From: Daniel Vick
Sent: 26 April 2019 10:05
To: [REDACTED]
Subject: AL/36/19/DOC

Engineers Comments Regarding Condition 4- surface water drainage

SKOL
PROPOSED S.I. WORKS
TP/CH LOCATIONS

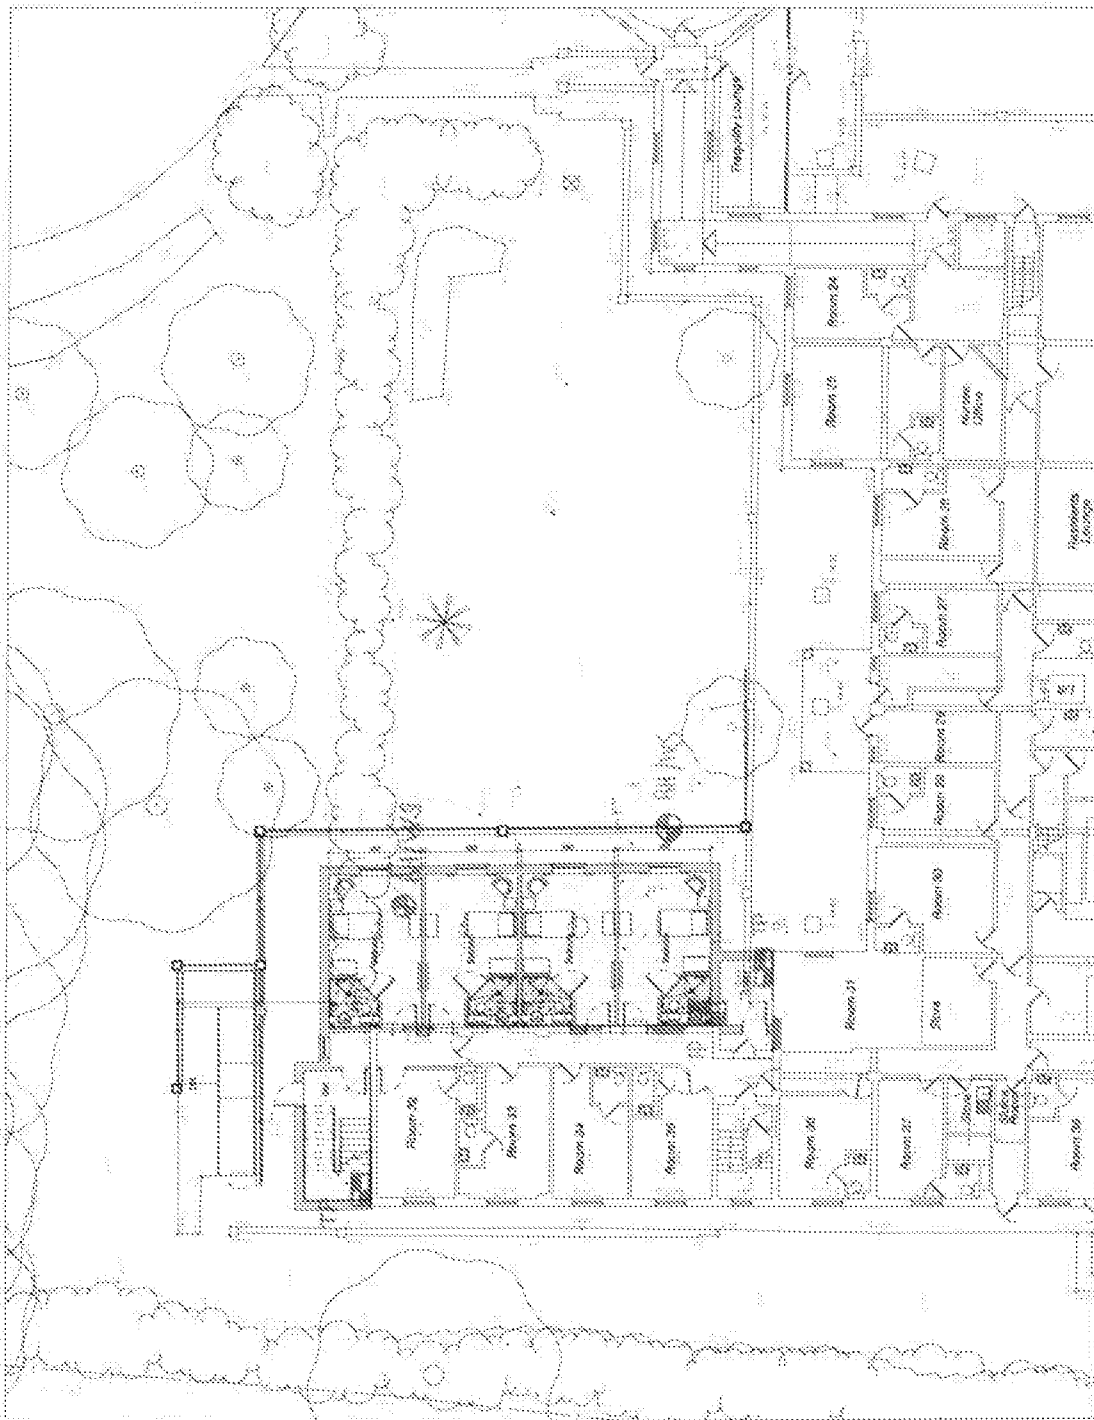
1. Please can a layout plan be provided which shows the location of the trial holes and groundwater monitoring points. The map provided does not include hole numbers.
2. The layout plan will need to be updated to include invert and cover levels of the soakaway.
3. Construction detail drawings need to show 100mm coarse sand bed and surround, and permeable geotextile.
4. Please provide construction detail drawings of pipe bedding and surround.
